Aspect Industrial Estate Stage 3 WH2 (SSD-58257960-Mod-2) Response to Submissions Letter

This response letter has been prepared by Urbis on behalf of Mirvac Industrial Developments Pty Ltd (Mircac) (**the Applicant**) in response to submissions from the Department of Planning, Housing and Infrastructure (**DPHI**) and Penrith City Council in connection with the above Modification Application for Warehouse 2 at the Aspect Industrial Estate under SSD-58257960.

DOCUMENT INFORMATION Swept Path Assessment - EV Truck Charging Station Recessed Docks, RSD access	FILE NAME AG2168-04-v02.dwg SHEET AG02
---	---

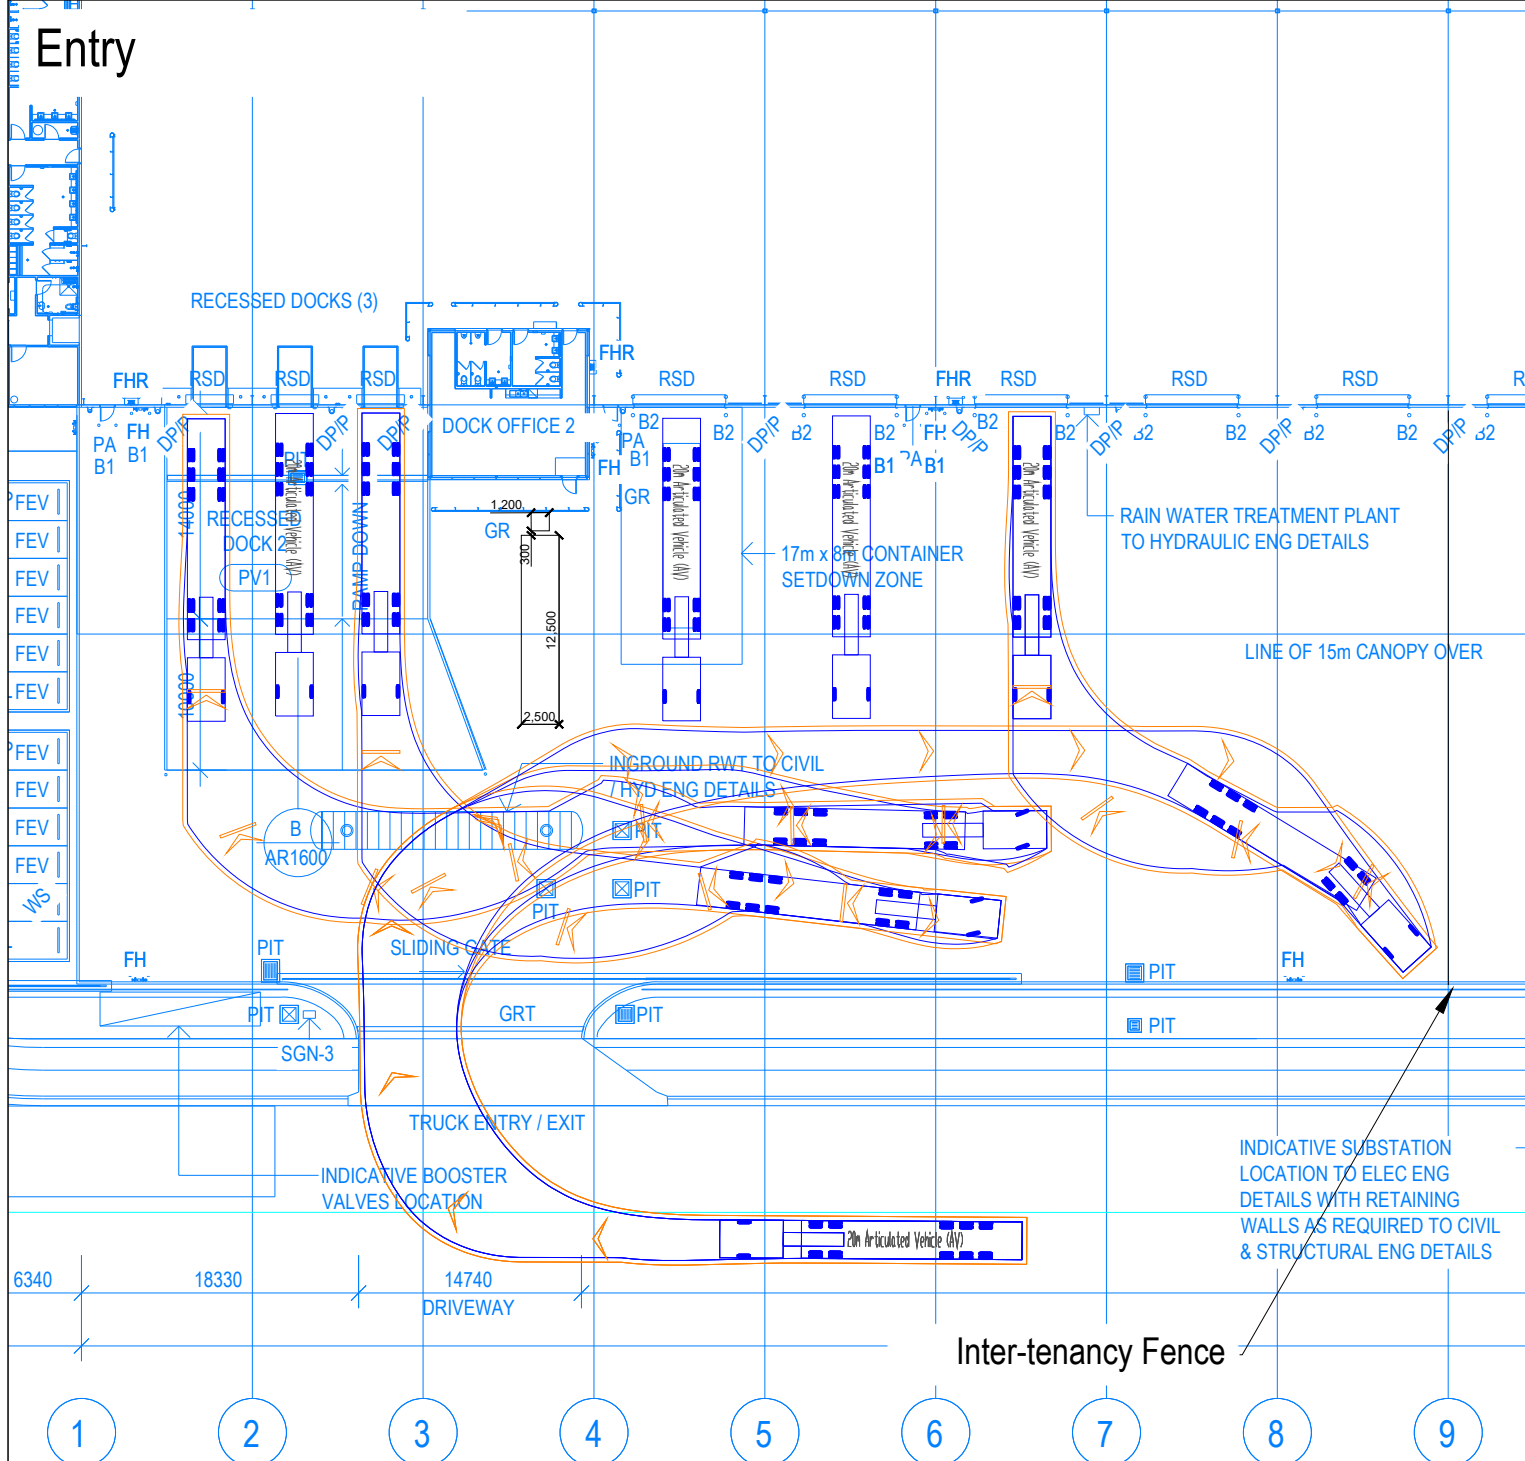
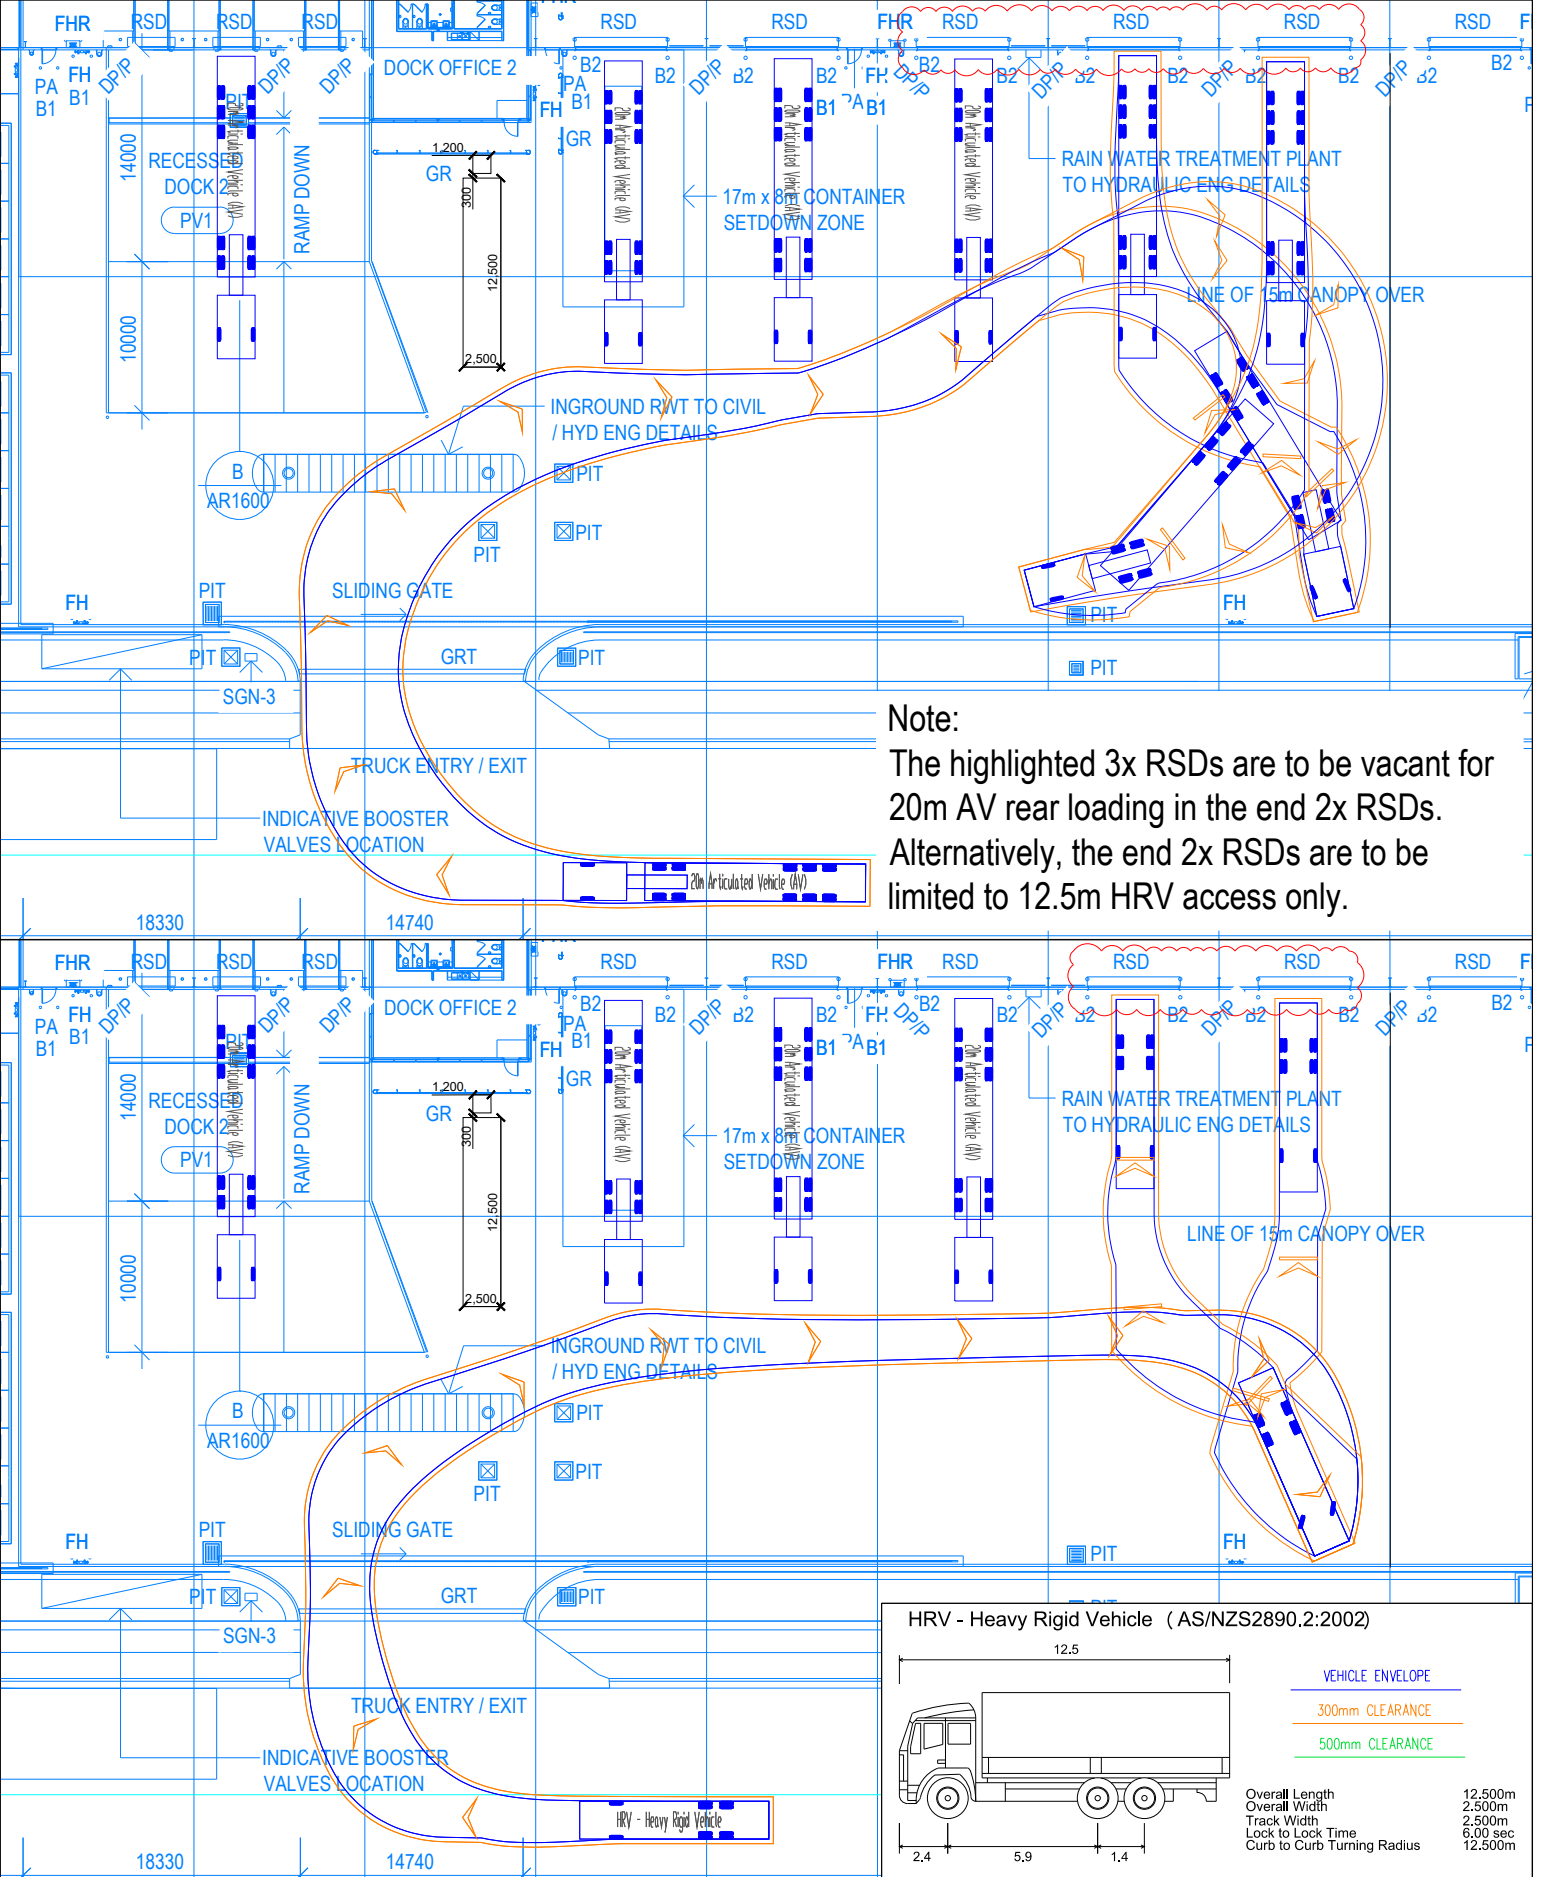
The plans indicate three recessed docks located on the western side of the warehouse adjacent to the temperature-controlled portion of the warehouse. The modification report also states that the temperature controlled area will be serviced by the three recessed loading docks. Clarify whether these three loading docks are to accommodate refrigerated trucks and how often each of the loading docks will be use.	The three loading docks adjacent to the temperature-controlled portion of the warehouse have the ability to accommodate refrigerated trucks, however the customer (tenant – TWL) has confirmed as per Attachment B, that no more than one refrigerated truck with the refrigeration unit operating will be on the hardstand/recessed docks at any one time (during the day, evening and night periods and operating continuously during the typical worst-case 15-minute periods). Warehouse 2 was speculatively developed as approved under SSD-58257960 and

Body and Date	Comment	Response
		therefore designed to ensure flexibility to cater for a range of future customers. The three loading docks were approved as part of the original detailed SSDA for the warehouse.
	Please provide details of the movements of refrigerated trucks on site, i.e. idling and manoeuvring in loading areas, and how this may impact on the operational noise assessed for the development and the wider estate. Please provide a worst-case scenario assessment for the number of refrigerated trucks accessing the site at one time.	As detailed above, no more than one refrigerated truck with the refrigeration unit operating will be on the hardstand/recessed docks at any one time. Truck movements and manoeuvring would be located within the hardstand area of the site, accessed via entry/exit driveways from the estate road. Modelled noise source locations representative of the operations of the site and are shown in Figure 5 of the NIA report. Results of the worst-case scenario noise assessment including refrigerated trucks are provided in Section 3 of the NIA report. Ason has provided updated swept path analysis (Attachment C) to demonstrate vehicle manoeuvring for the recessed docks and proposed tenancy operations and accessed via the entry and exit driveways.
